Rezoning Transportation Analysis

Petition Number: #2021-256

Date	Description
04-12-2022	First Review (AO)
08-22-2022	Second Review (AO)
01-25-2023	Third Review (TM)
03-22-2023	Fourth Review (DR)
04-20-23	Fifth Review (TM)
06-21-23	Sixth Review (DR)

RZ-3

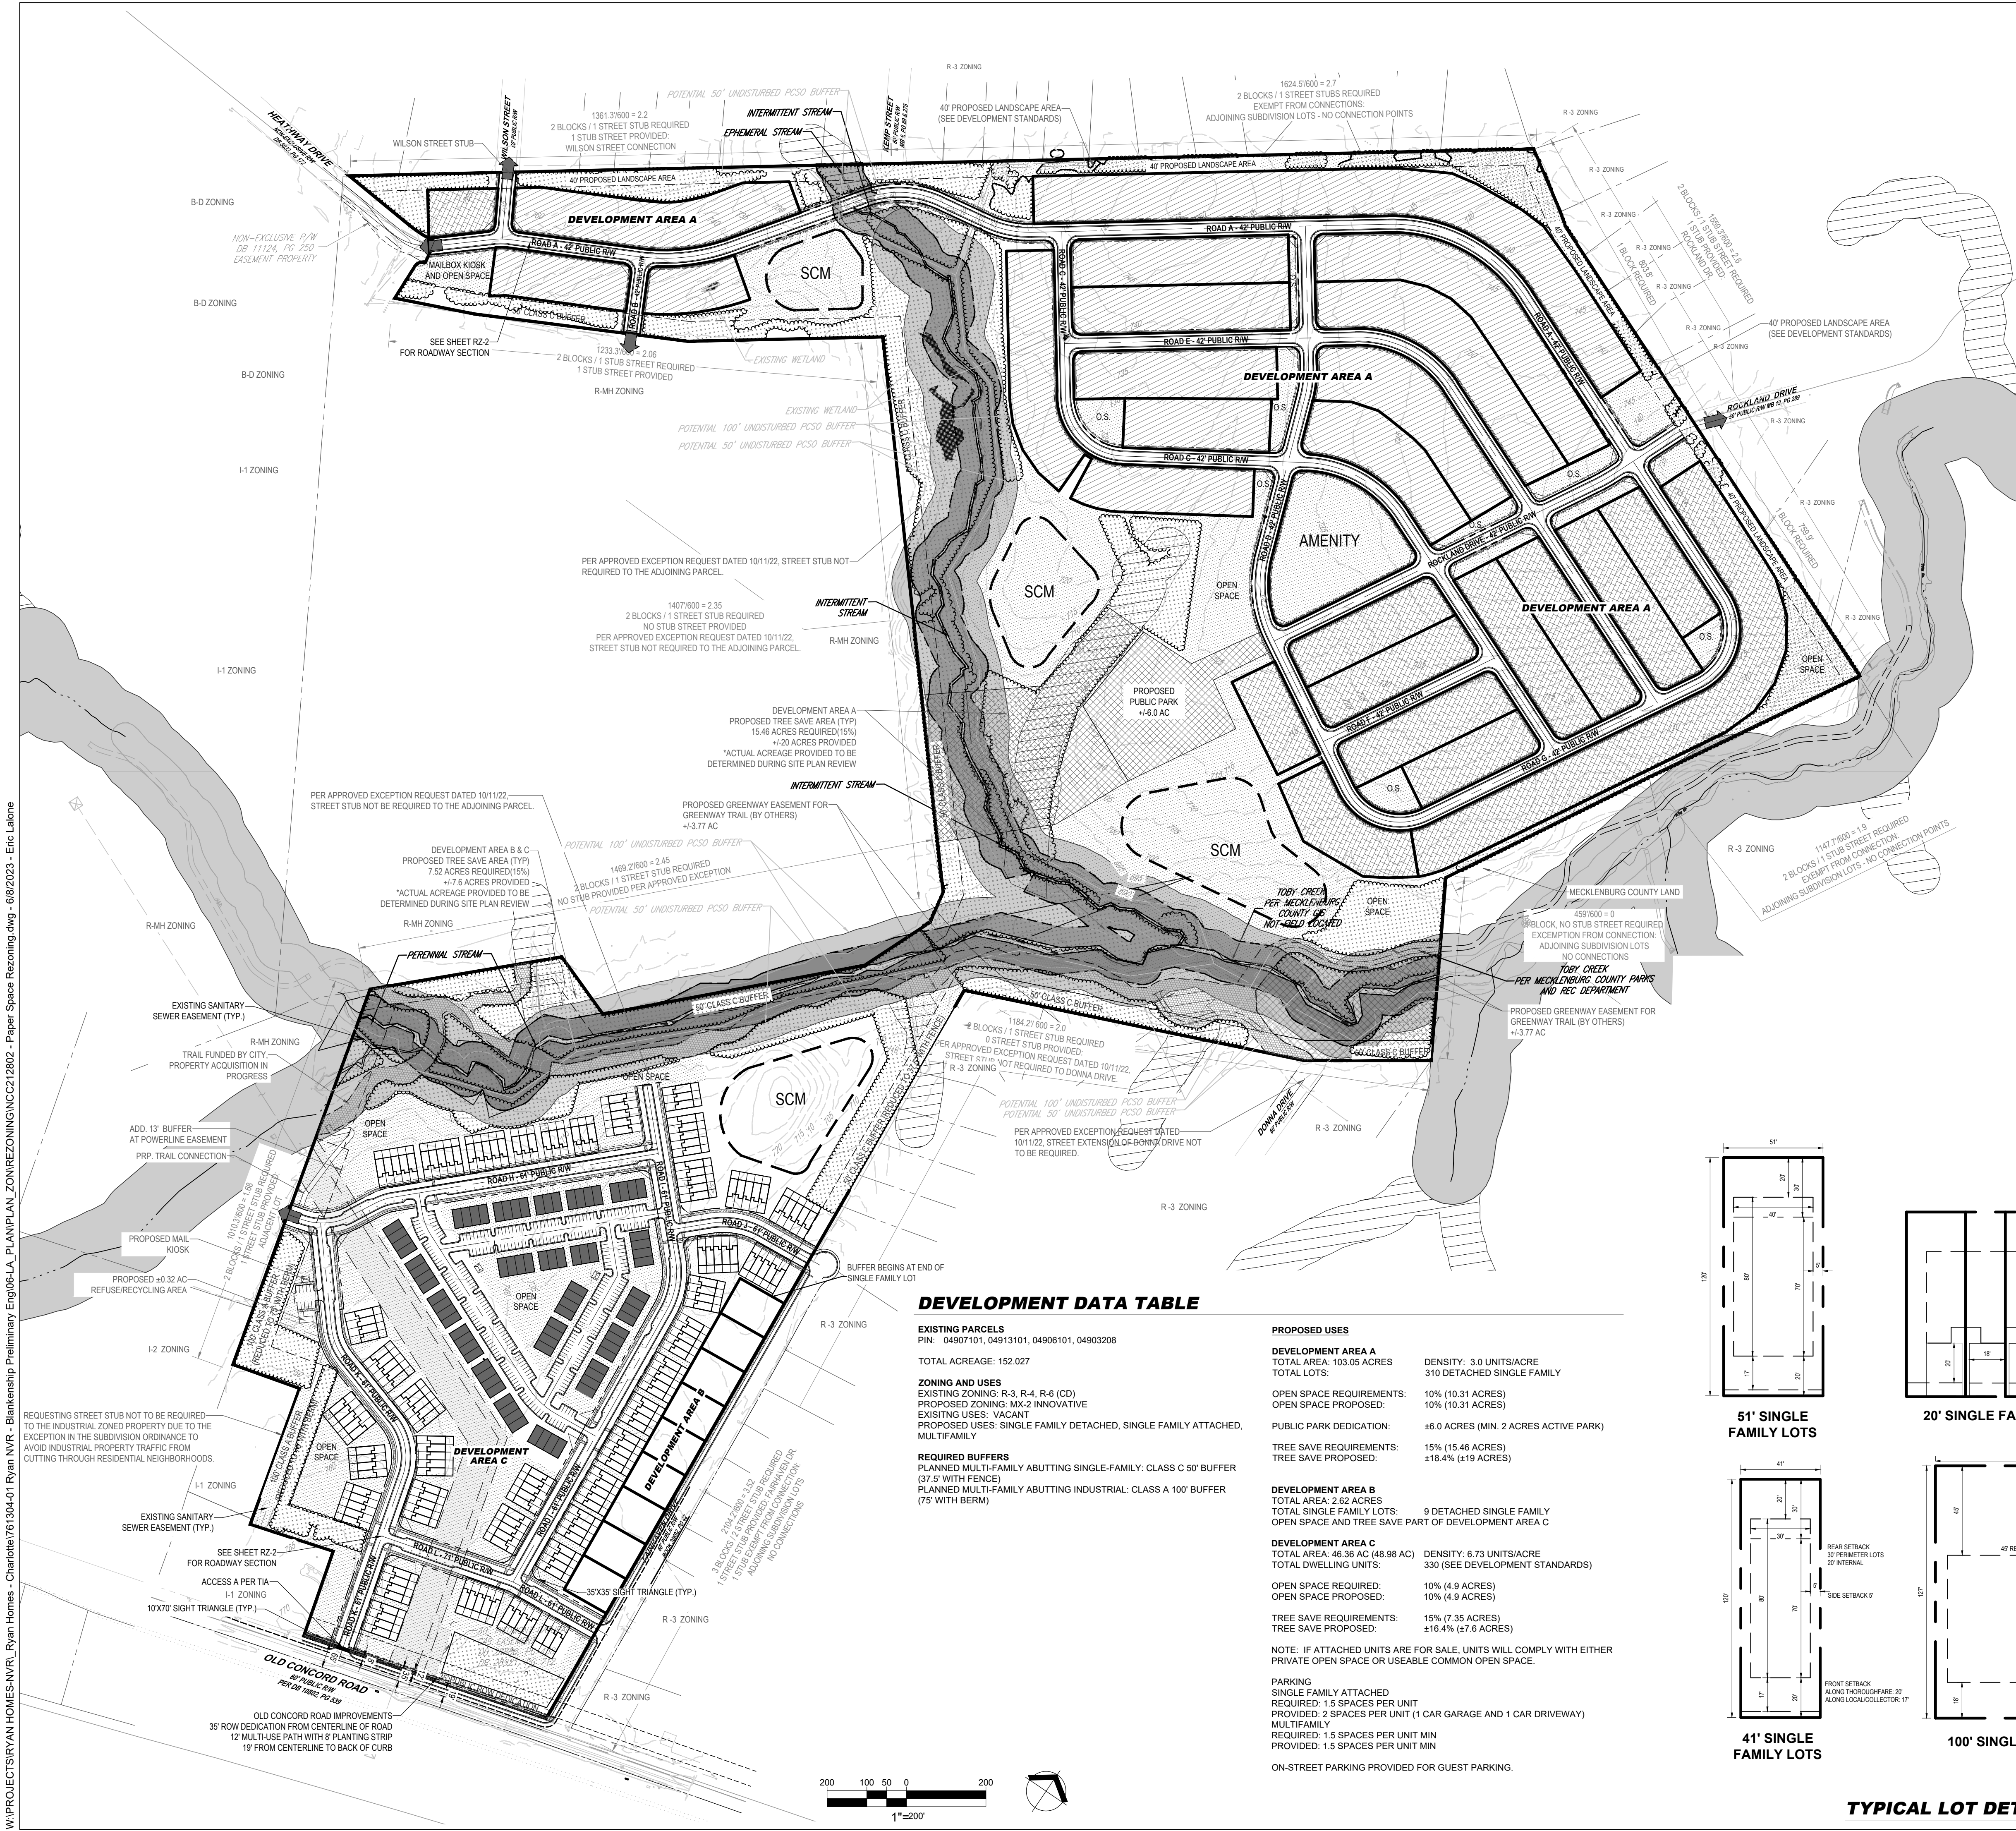
10. **Outstanding Comment from 4-12-22:** ~~Revise site plan and conditional note(s) to commit to constructing a 12' multi-use path connecting Neal Drive to Development Area "A" to provide connectivity from XCLT to eastern leg of Neal Drive.~~

Comment Rescinded (01-25-23): Add multi-use path to site plan sheet RZ-3 and add conditional note to development standards.
